City of Portland, Maine - Building or Use Permit Application

Permit No: 09-1359	Issue Date:	CBL: 013 E012001
-----------------------	-------------	---------------------

Past Use: Commercial - connected to permit #09-0275 (see for use)	Proposed Use: Commercial / Install stairs and ramp from 3rd level to ground level to meet egress.	Permit Fee: \$70.00	Cost of Work: \$5,000.00	CEO District: 1
		FIRE DEPT: <input type="checkbox"/> Approved <input type="checkbox"/> Denied	INSPECTION: Use Group: Type:

**ELEVATION @  
ROOF RAMP**

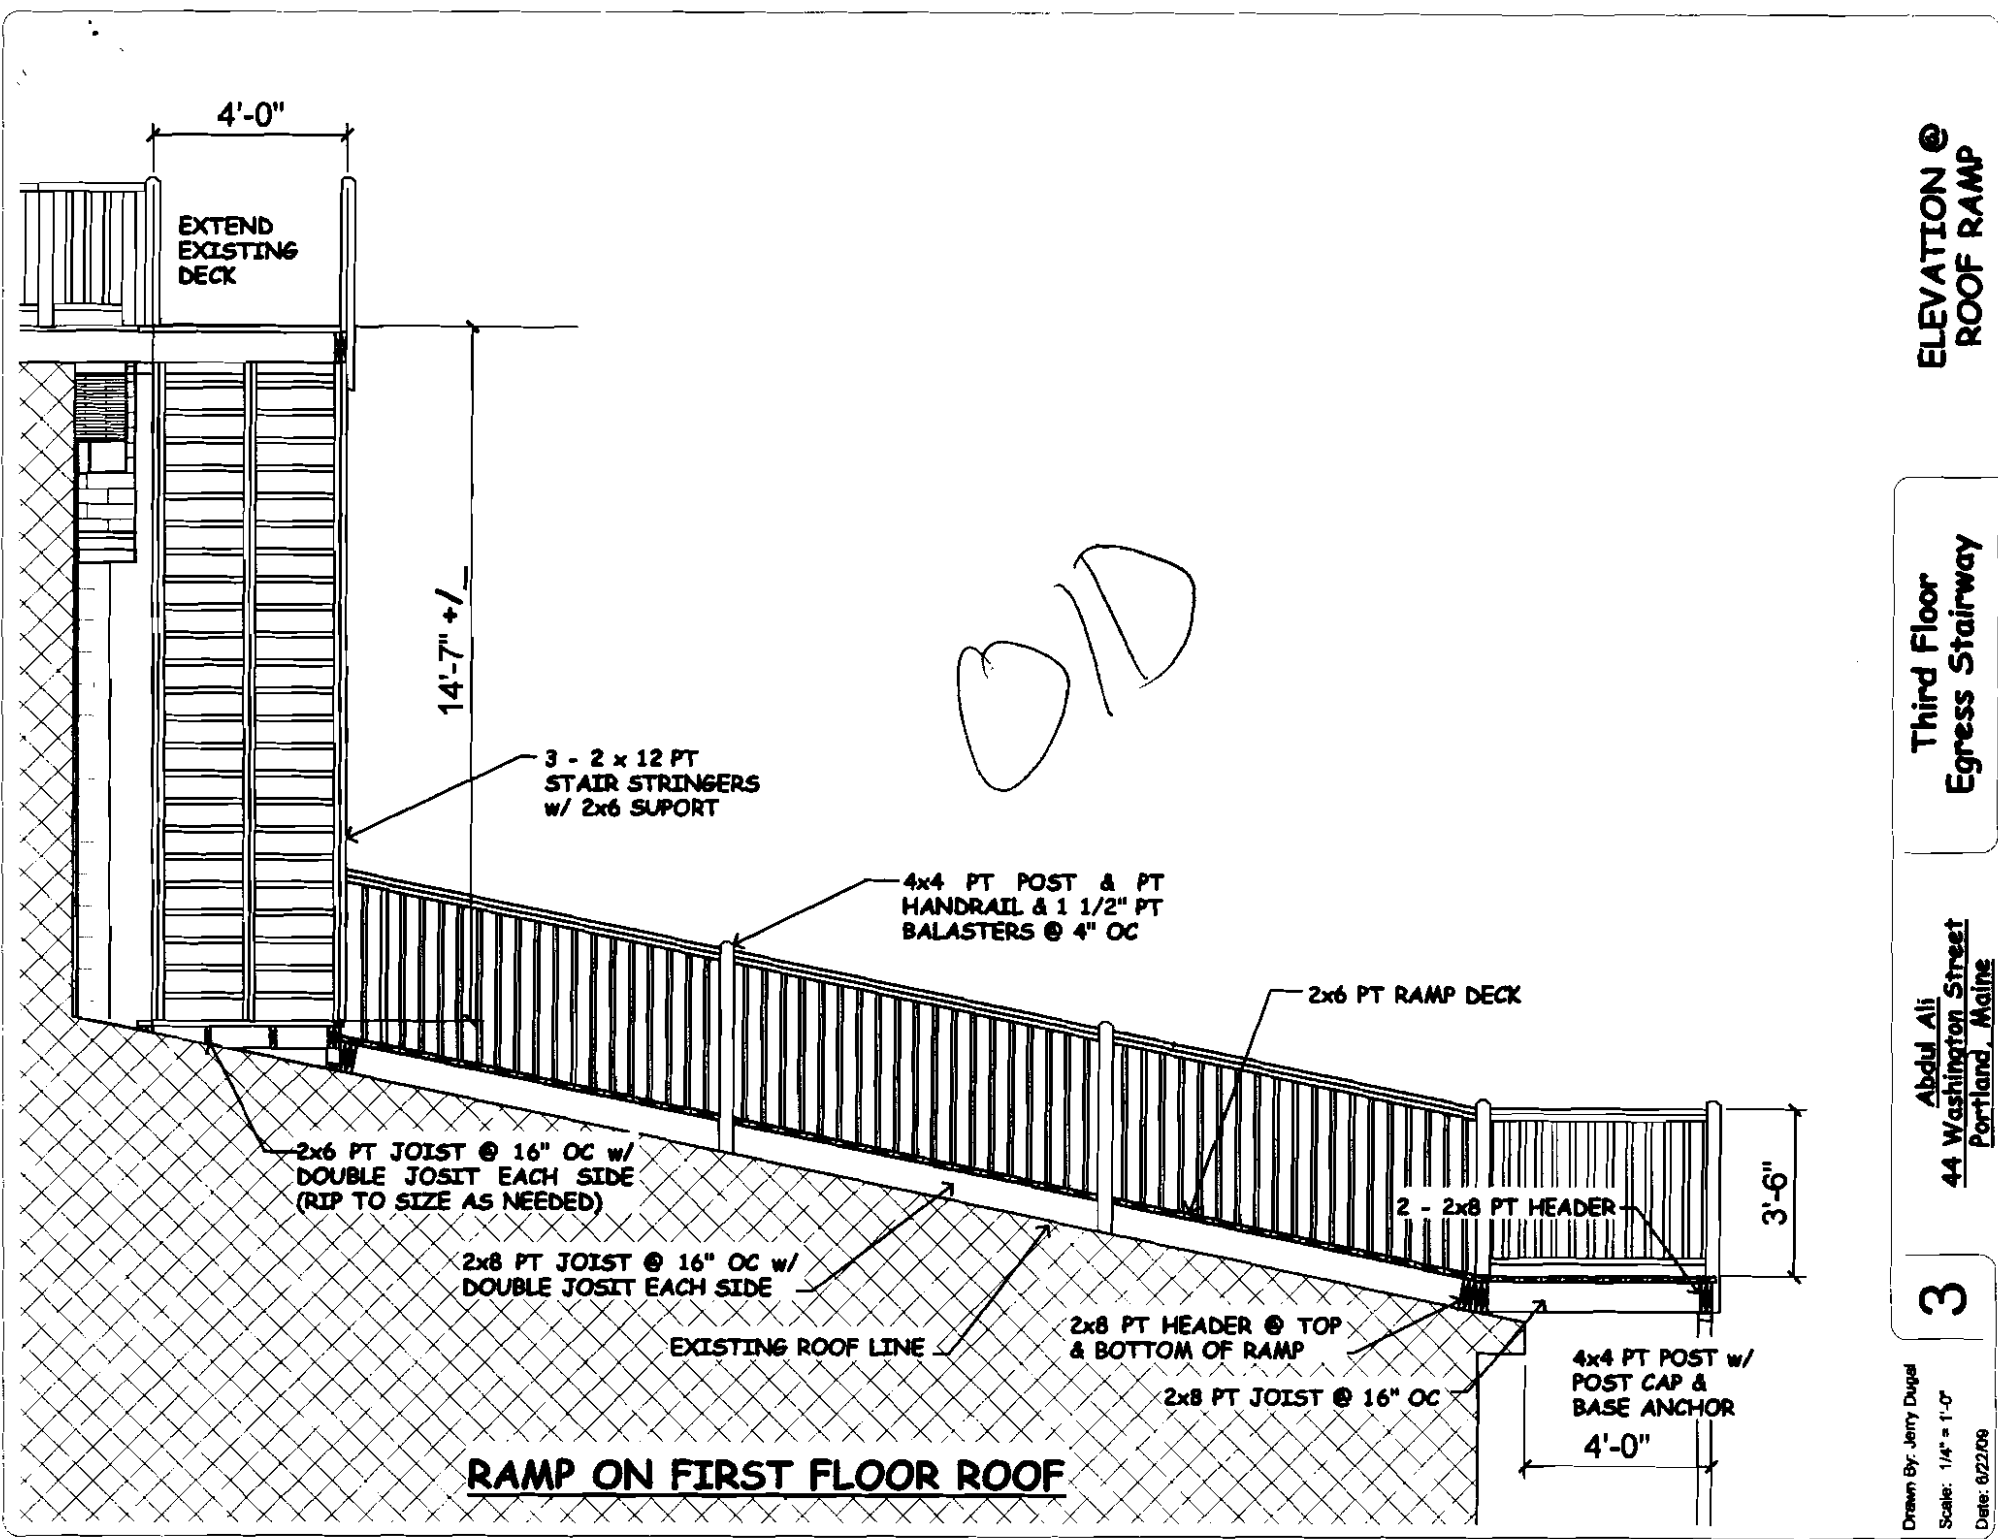
1) Elevation of the final stairs to grade shows 12', if more an intermediate landing will be required			
2) Application approval based upon information provided by applicant, with revisions dated 4/20/10. Any deviation from approved plans requires separate review and approval prior to work.			
Dept: Fire	Status: Approved with Conditions	Reviewer: Capt Keith Gautreau	Approval Date: 04/21/2010
Note:			Ok to Issue: <input checked="" type="checkbox"/>

4/30/2010-jmb: Spoke to Jim M. About the 12' height to grade, he thinks it is less, but will notify if more and may have to do an intermediate landing, ok to issue
